PLANNING AMENDMENT

Application No. H17/0480/96
Date Registered 09 DEC 1996
Case Officer *fu*

*~~Site~~ change of use
of agricultural building
to workshop of
conservatories*

THE LANDSCAPING OF
ASH TREE HOUSE

PROPOSED GARAGE FOR MILDRED SALVAGE
ASH TREE HOUSE
BIRCHES DRIVE
SLIPFLOP

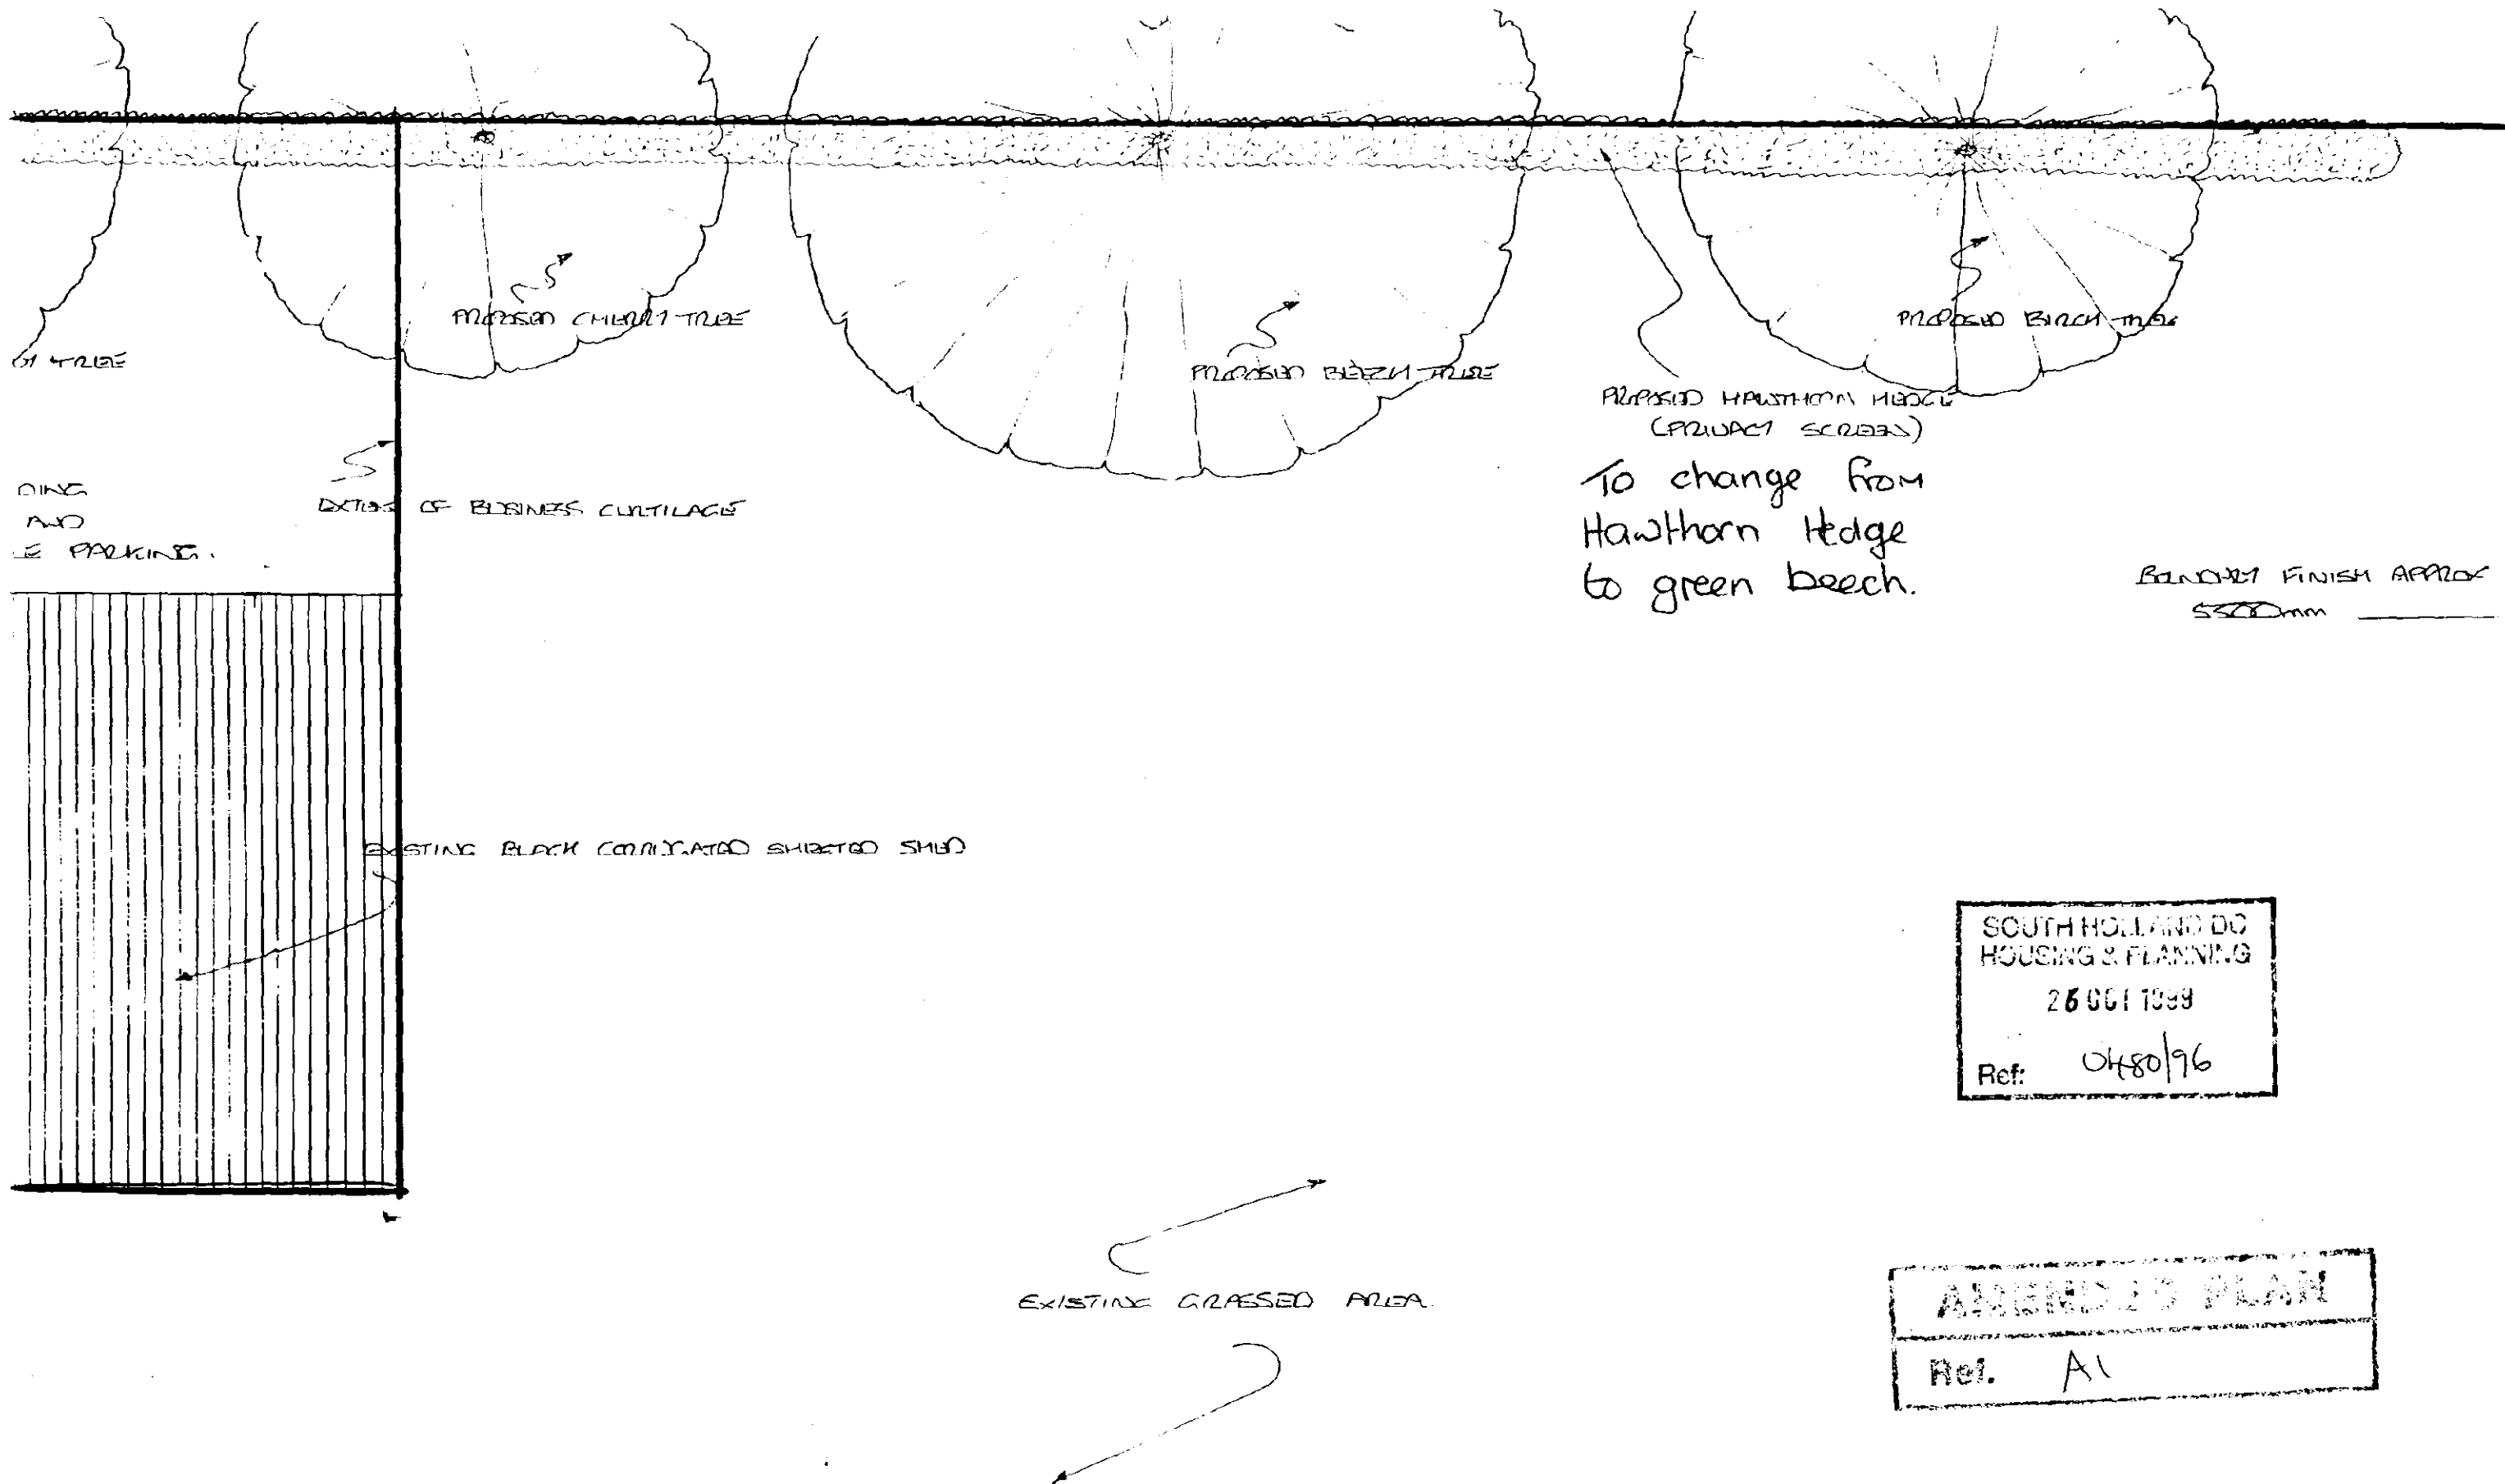
*Siting of Triple
Garage + relocate
Access*

AMENDED PLAN
Ref. A1

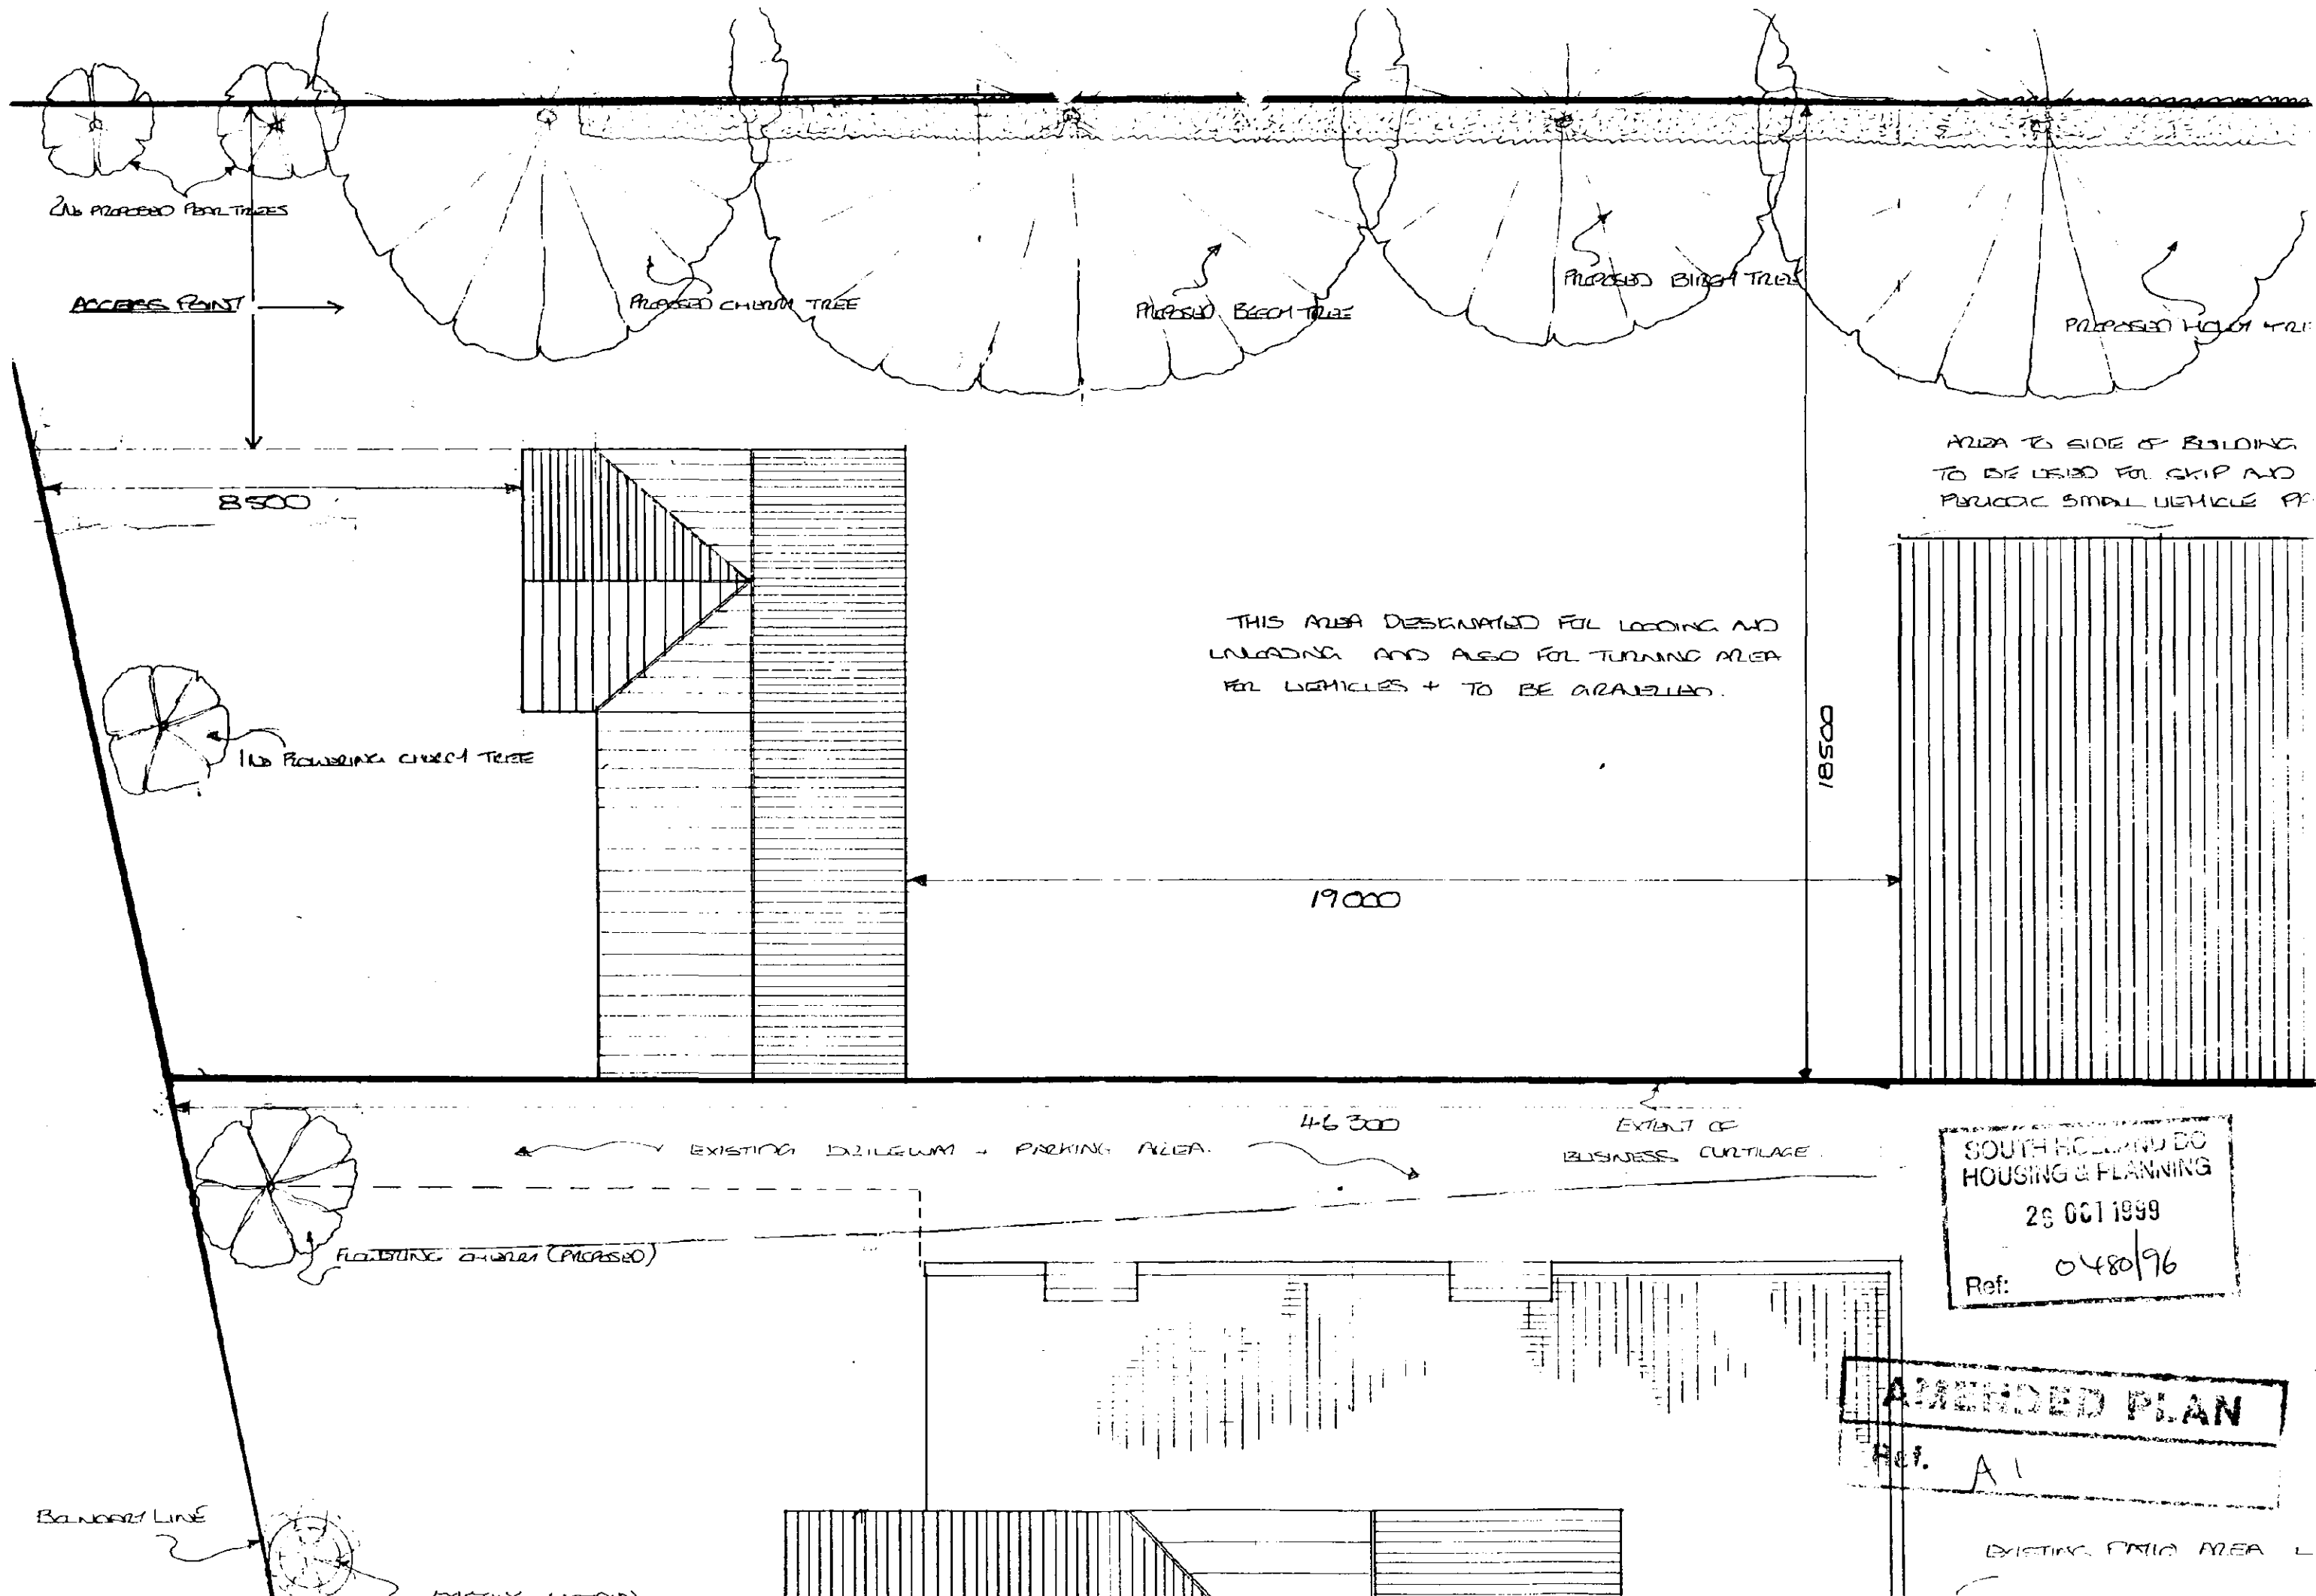
To change from hawthorn
hedge to green beech.

Amendment: Change hawthorn hedge to green beech

The amended details submitted in respect of the above proposal have now been considered and there are no objections to the amendment being implemented to the extent described above.
